From: Liz Annalls [REDACTED]
Sent: 14 October 2020 10:39
To: Planning.Responses <Planning.Responses@arun.gov.uk>
Subject: RE: Planning Consultation on: WA/68/20/OUT

Application No: WA/68/20/OUT
Site Address: Land west of Tye Lane Walberton
Description of Works: Outline application with all matters reserved, other than means of access, for the construction of up to 155 No. dwellings (30% affordable homes) & amendment to boundary of garden land to serve adjoining property. This application affects the character & appearance of the Walberton Village Conservation Area, may affect the setting of listed buildings & is a Departure from the Development Plan.

Figure 15. The location of 'dark zones' throughout the proposed development where no artificial light will be used or directed towards.

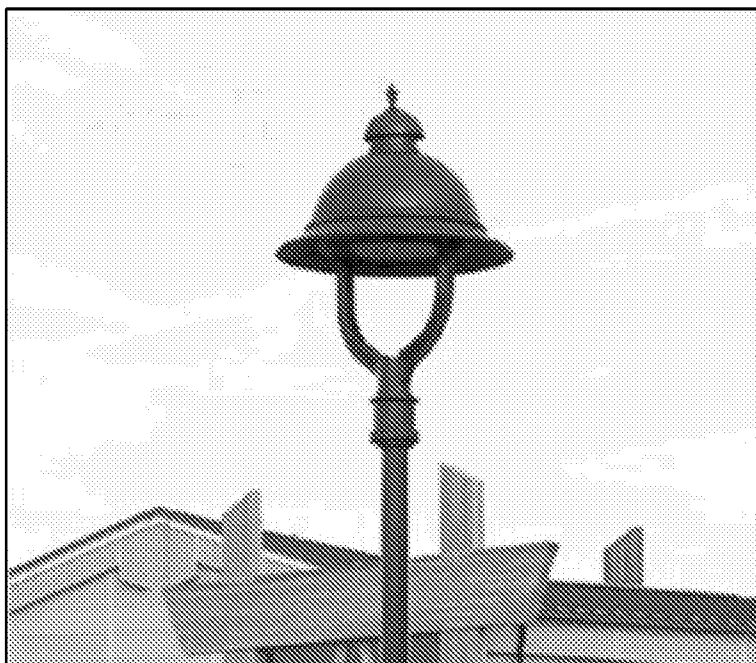
The lighting scheme for the site will need to take into consideration the presence of bats in the local area and the scheme should minimise potential impacts to any bats using the trees, hedgerows and buildings by avoiding unnecessary artificial light spill through the use of directional light sources and shielding.
